Our Ref: M/55/12/

Application for Planning Permission for Works or Extension to a Dwelling

Development Side and rear single storey flat roof extension

Location 8 Hadley Close Middleton On Sea

BLOCK PLAN 1:200

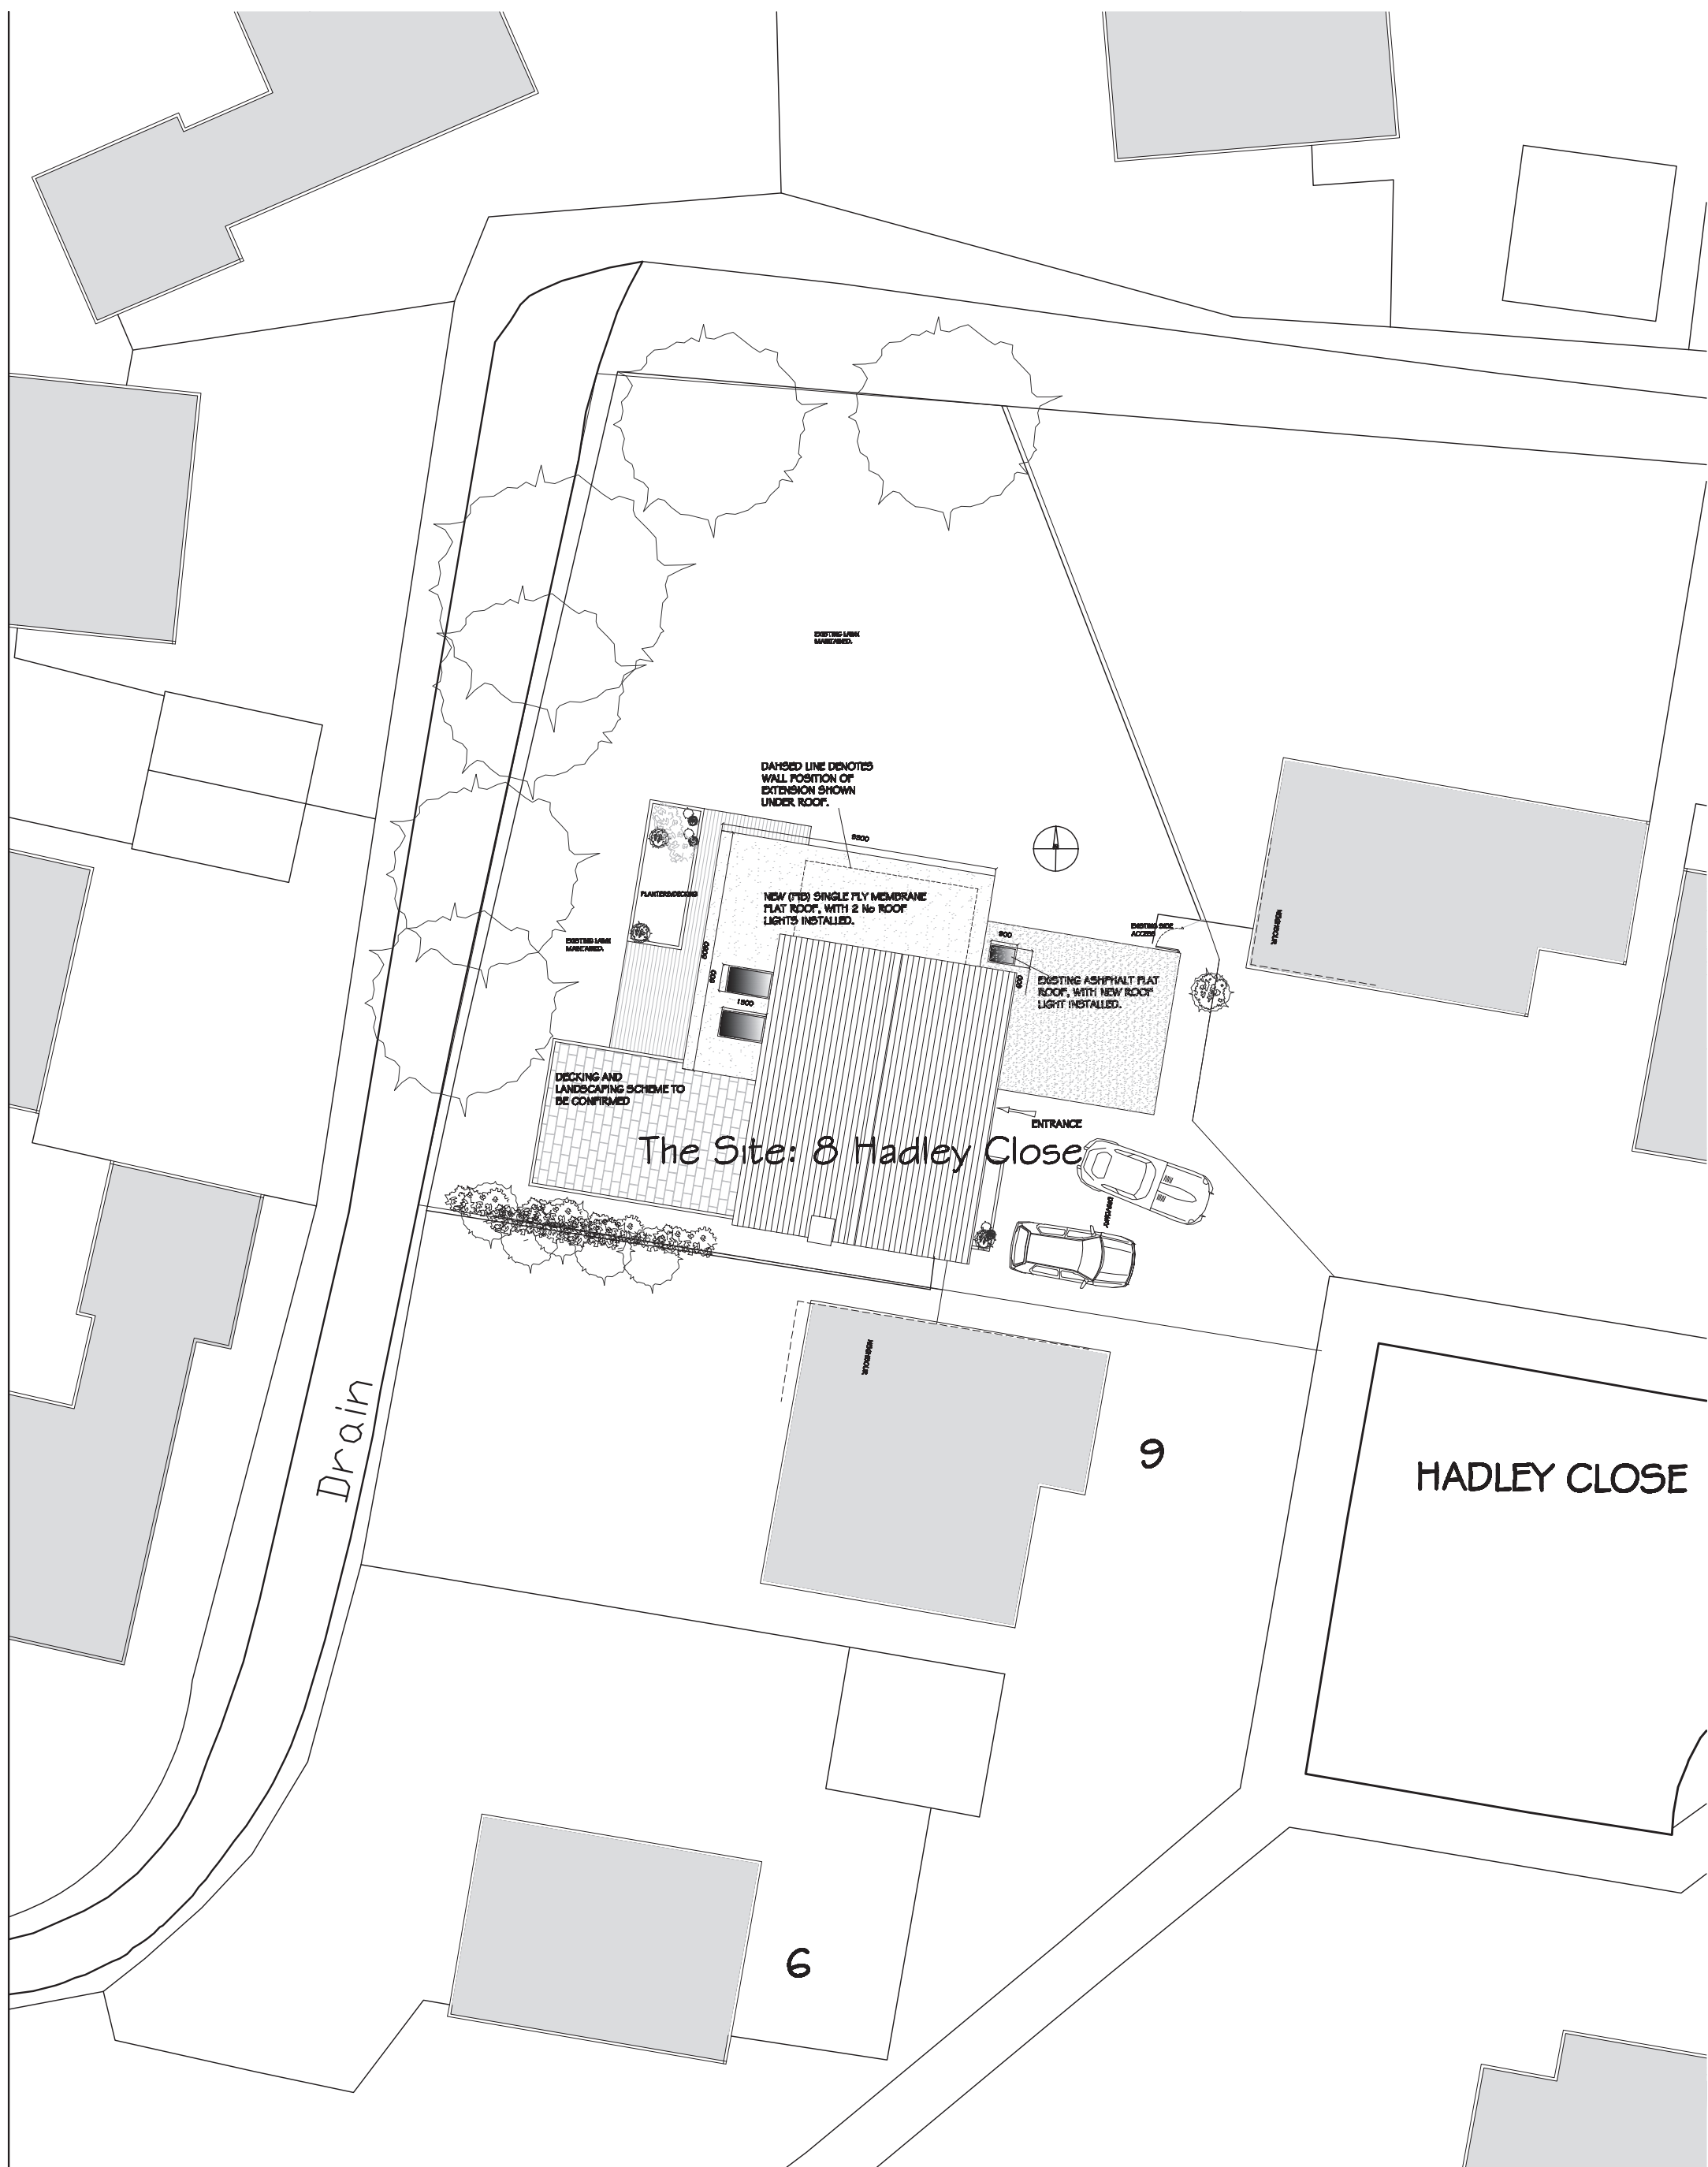
I require 1 electronic or 3 paper copies of a revised block/site plan with the proposed rooflights clearly shown in accordance with the guidance notes available on our website detailed below (click on National List).
